Submission Objecting to State Significant Development (SSD-78493518)

2-8 Highgate Road, Lindfield NSW 2070

Figure 34 Extract of proposed plans showing Level 1 plans.

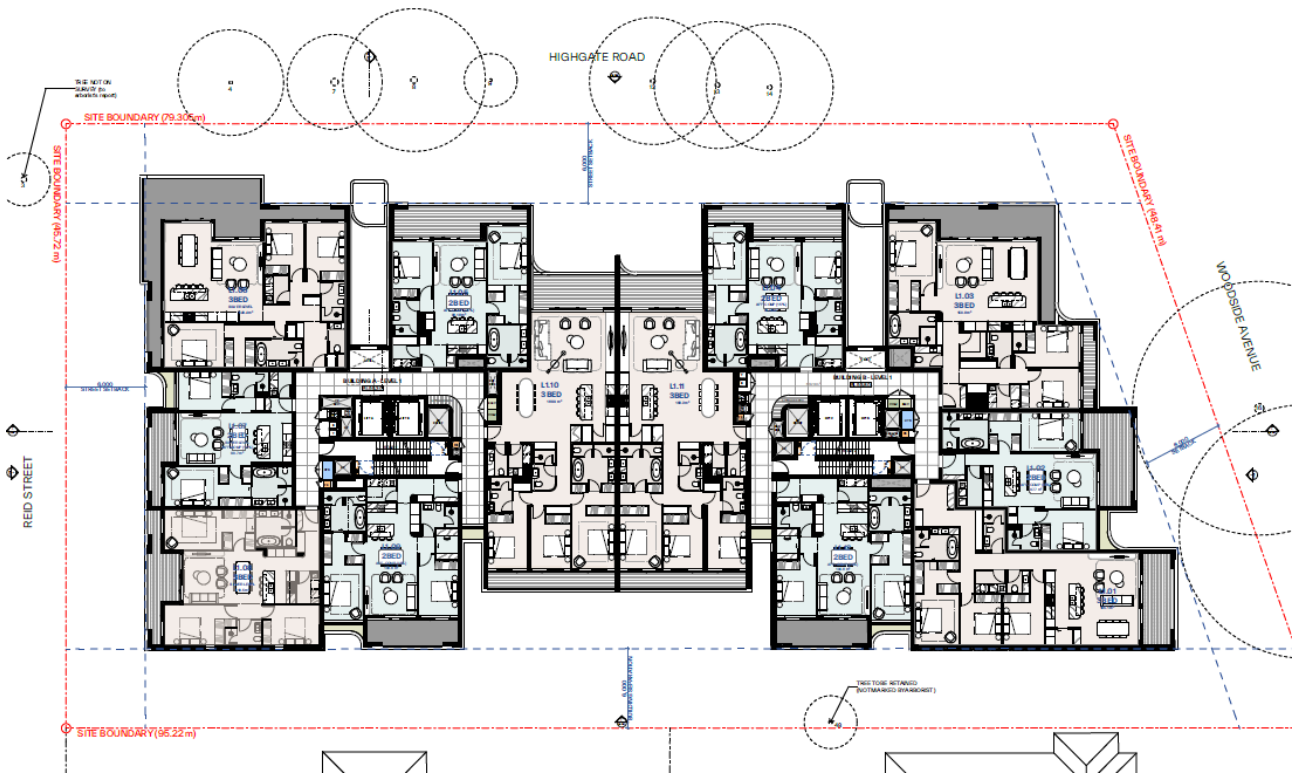
- Upper-level setbacks (Levels 4–5) do not universally achieve the required 9m, particularly along the northern edge (Figure 34 of EIS), exacerbating overshadowing and bulk impacts.
